Markup Summary

dsdrice (32)

ED-1

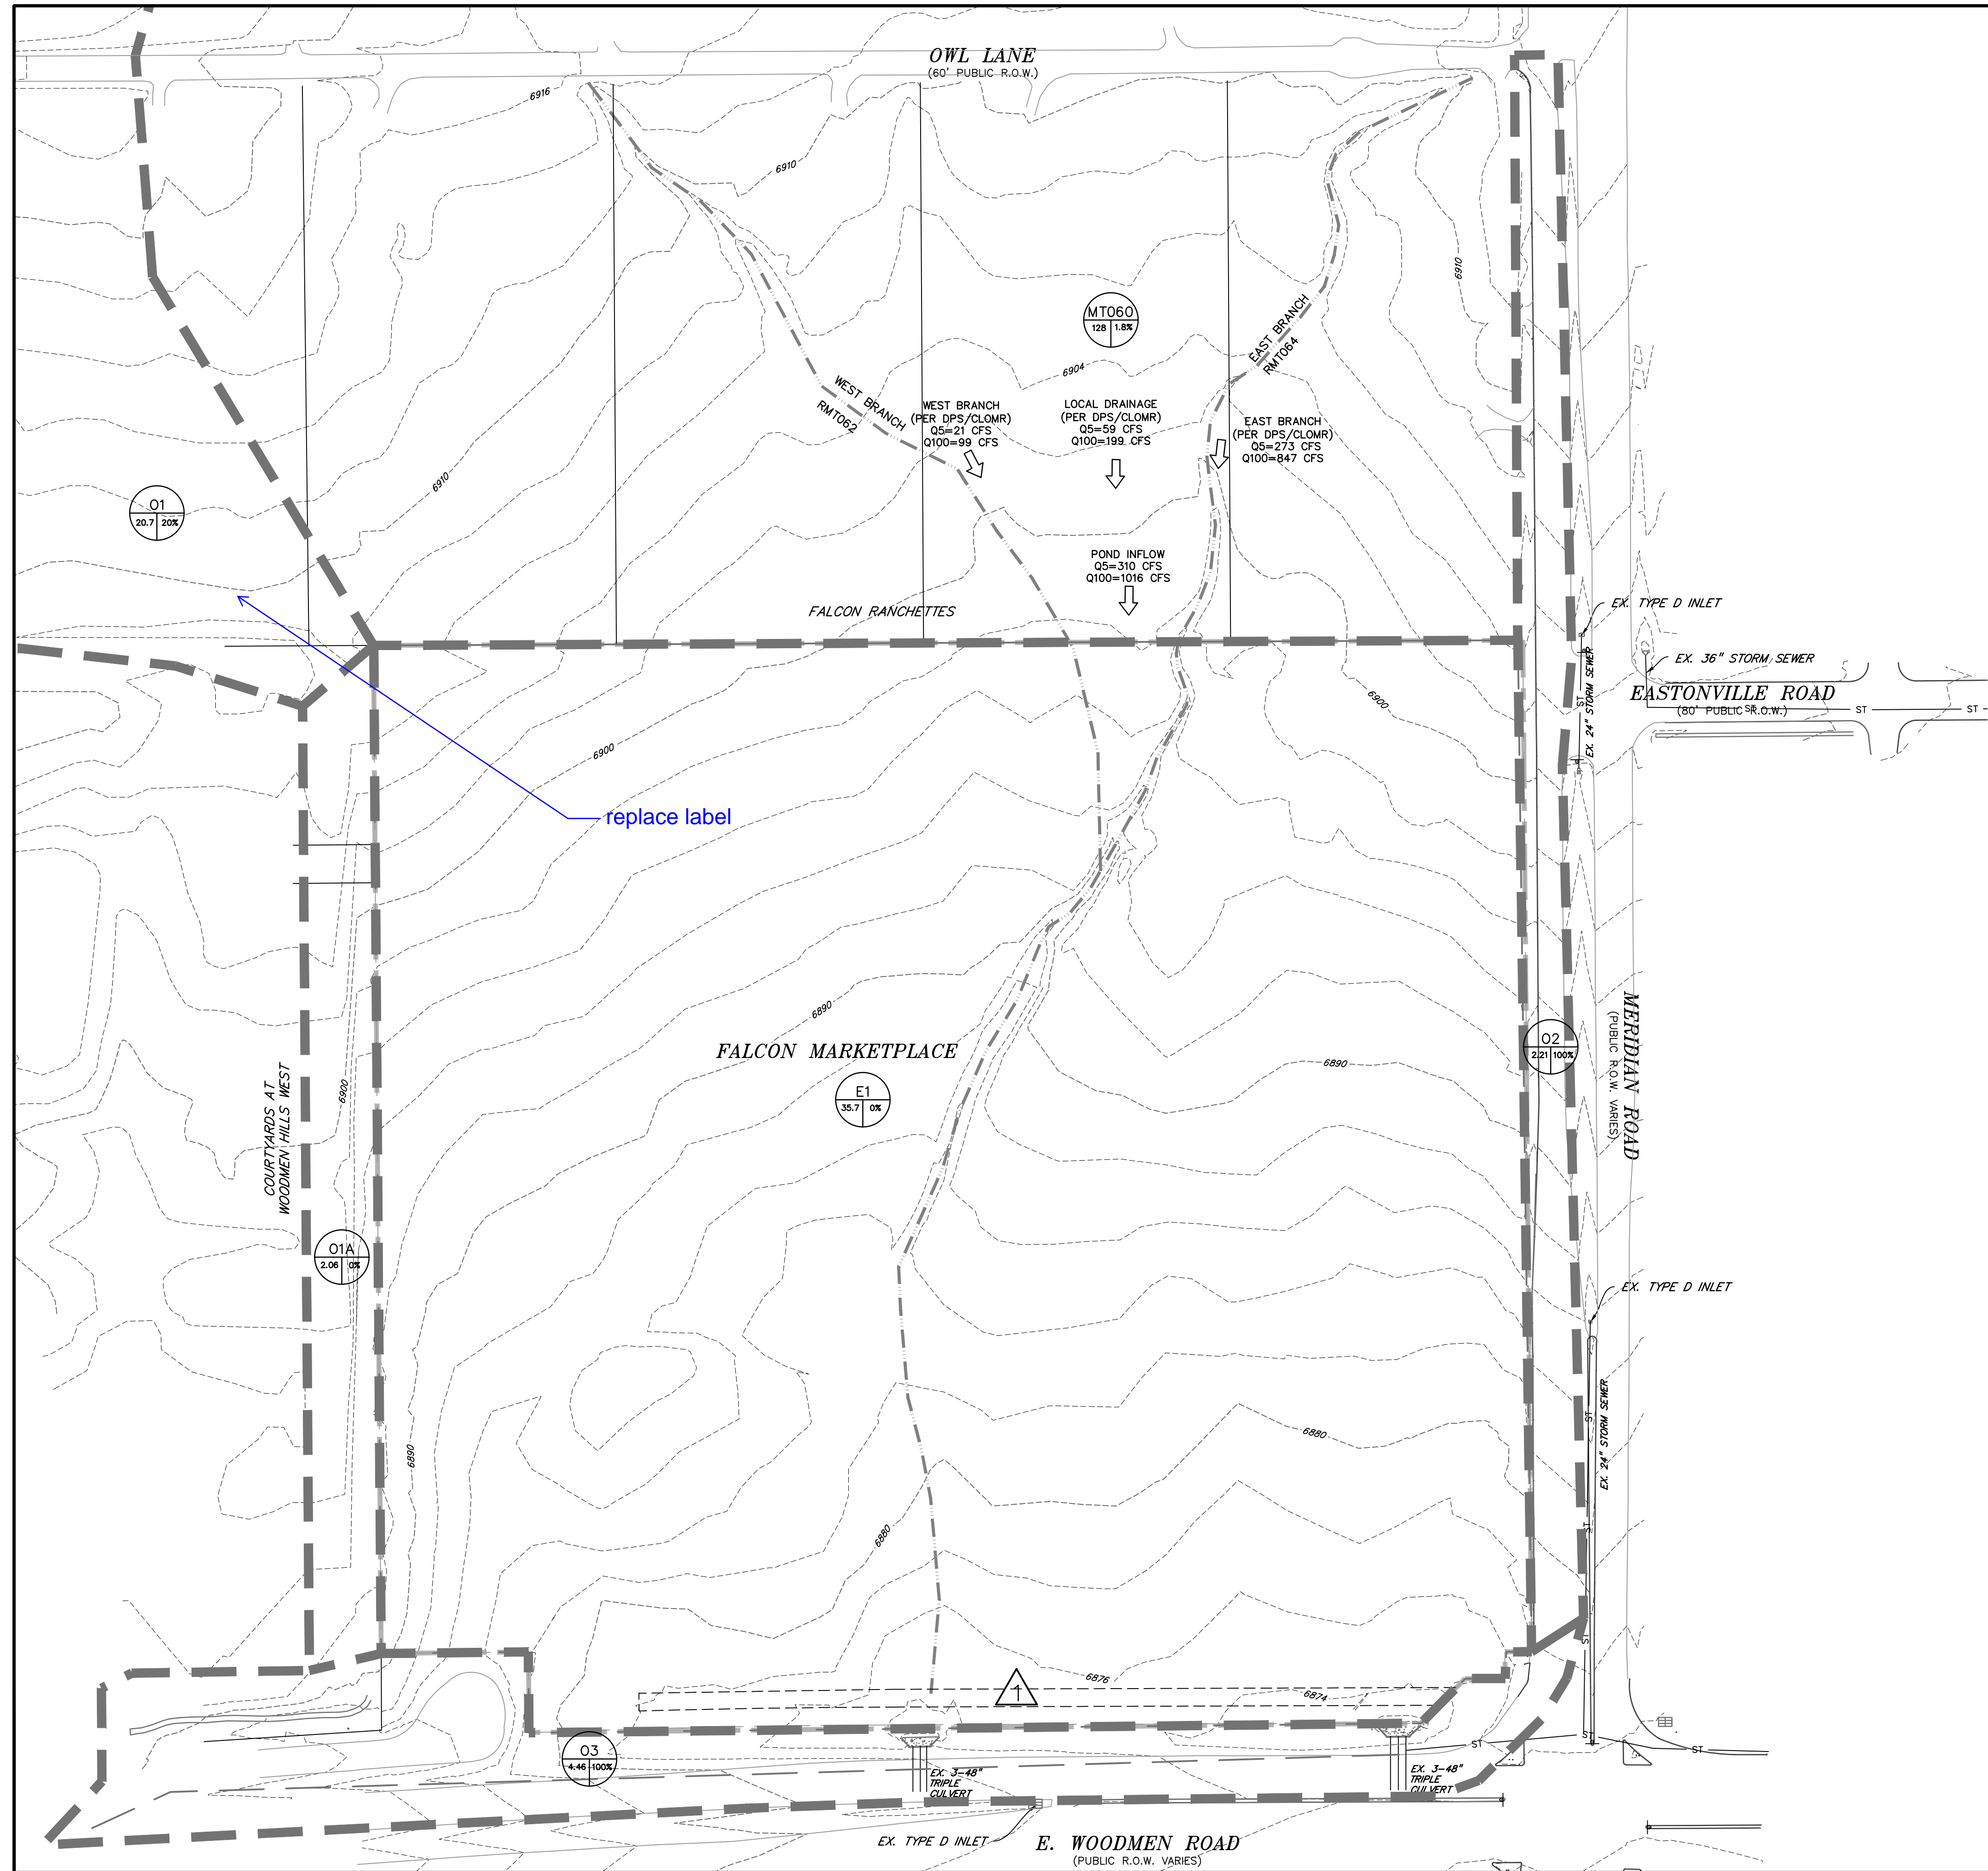
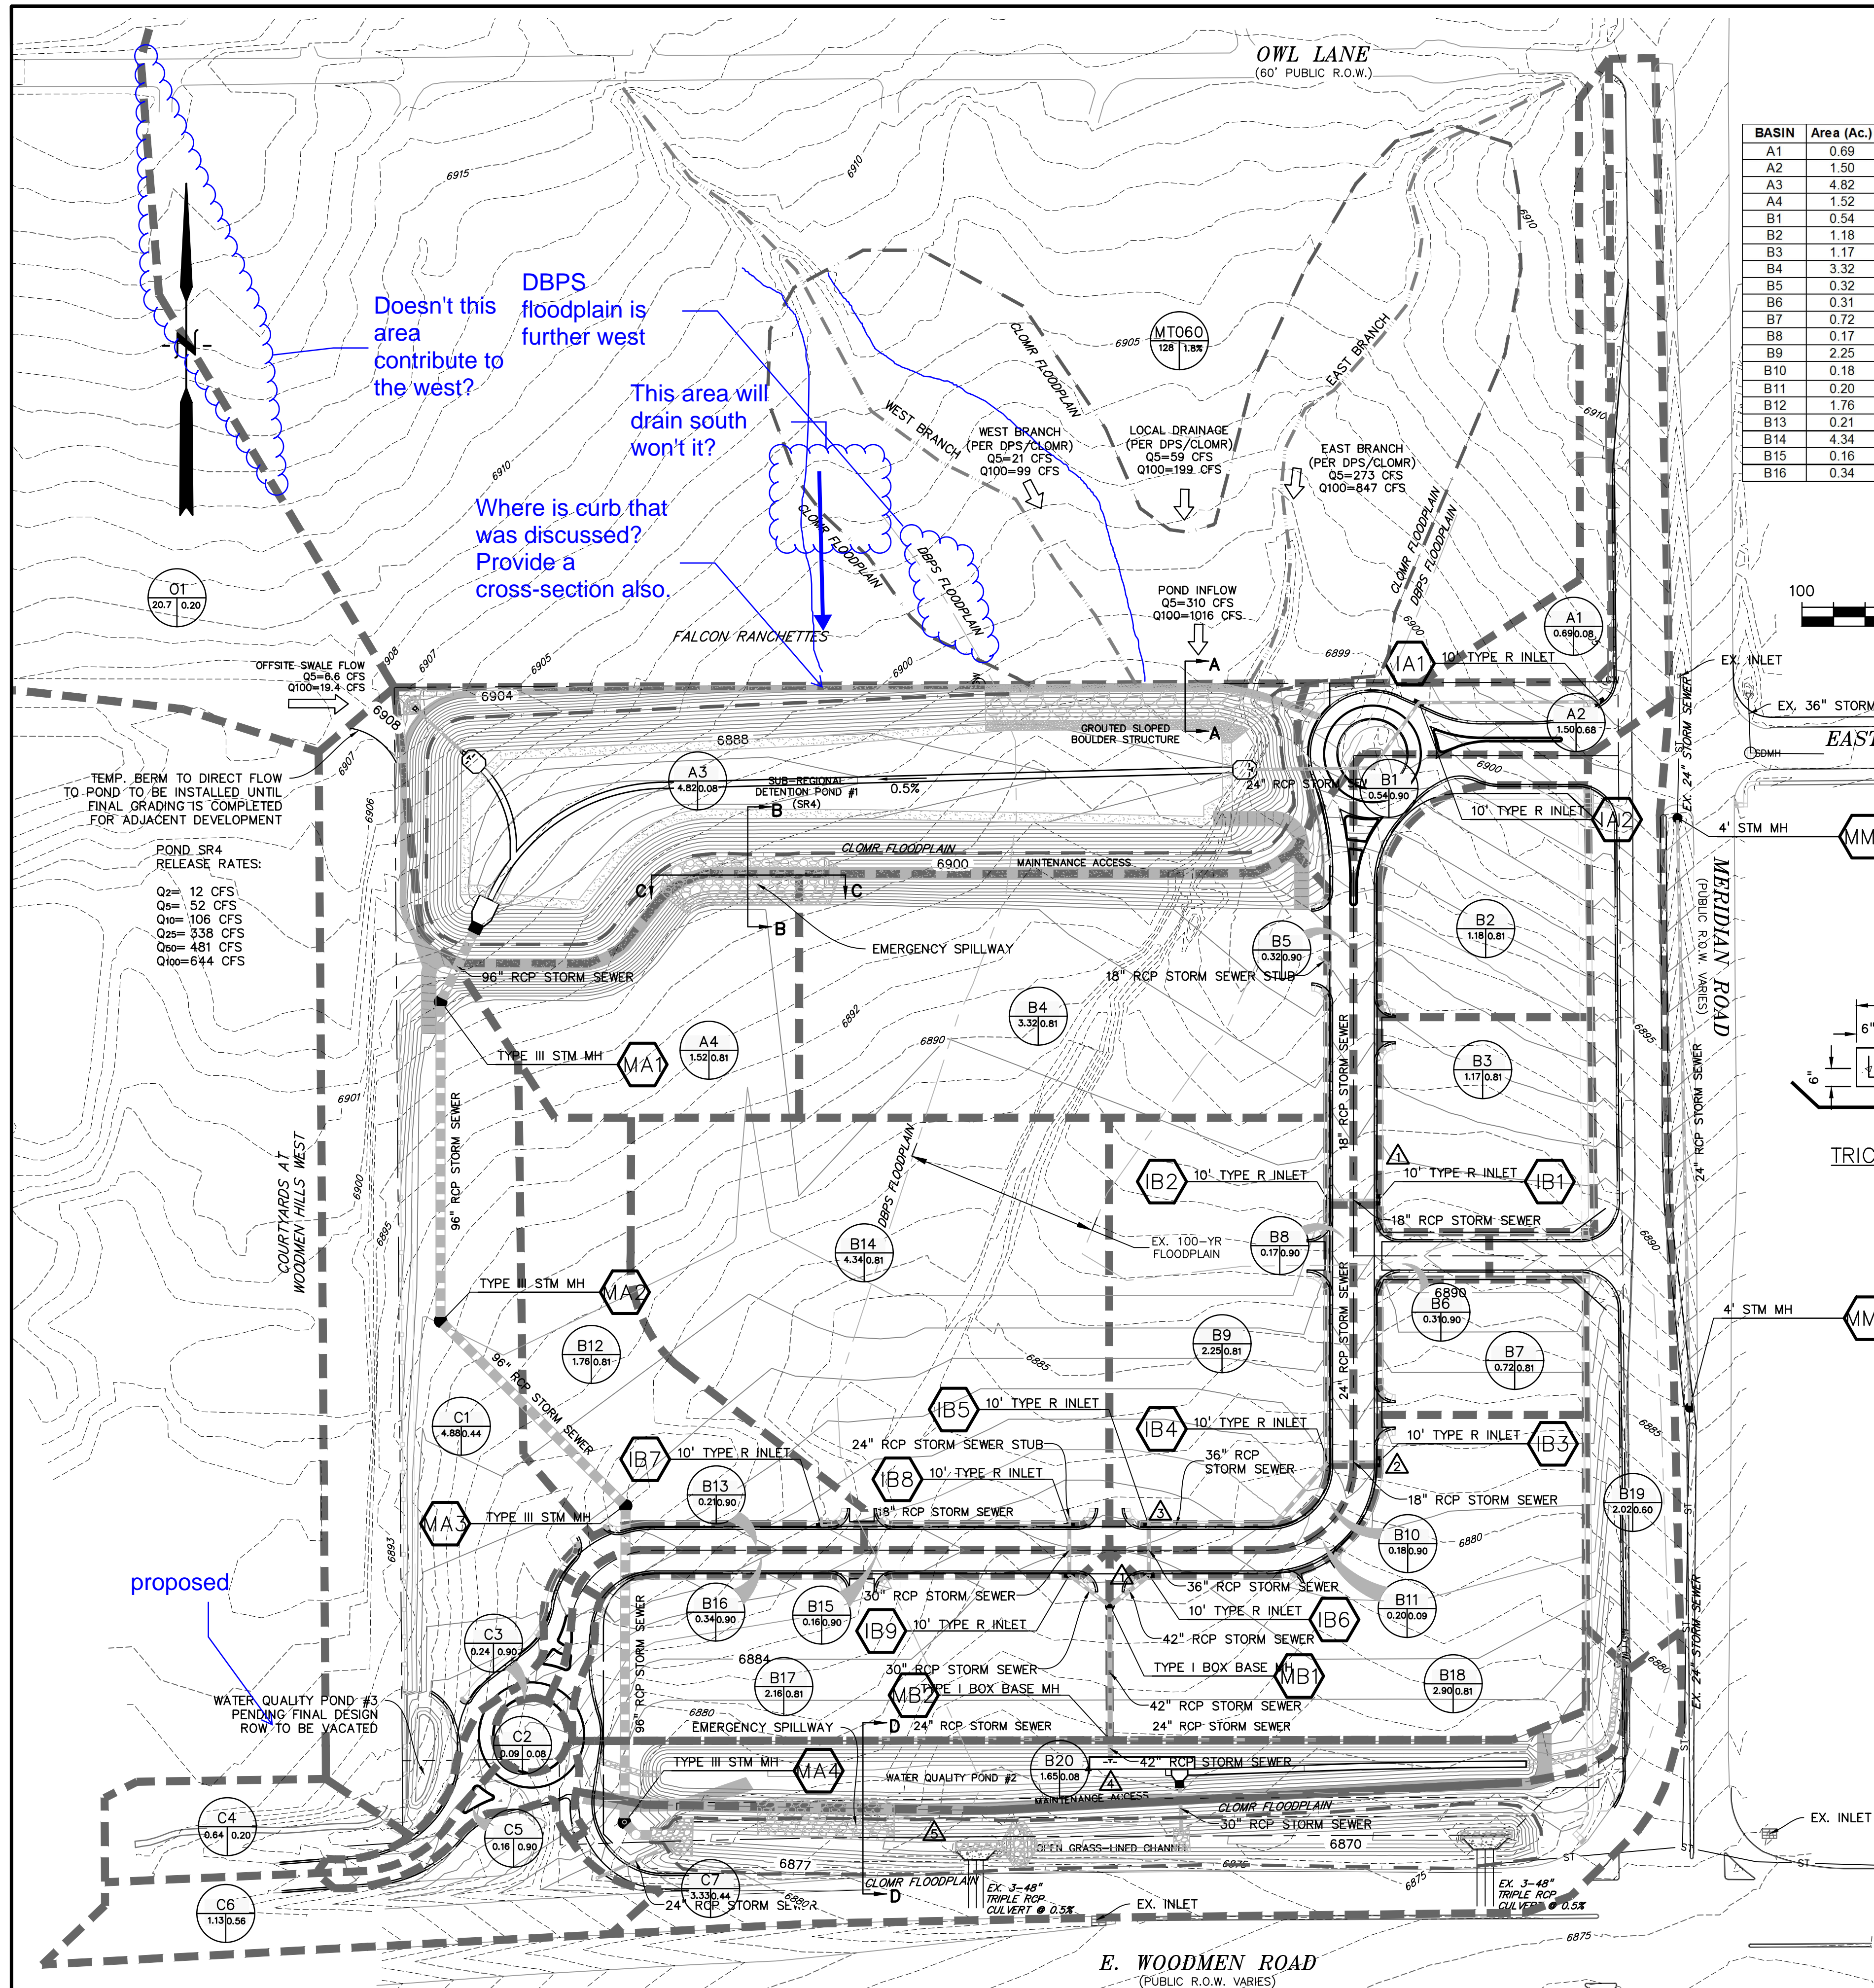
Show and label all offsite design points and sub-basins.

Show and label all offsite design points and sub-basins.

Provide calculations showing width and depth of flows entering pond at all applicable locations.
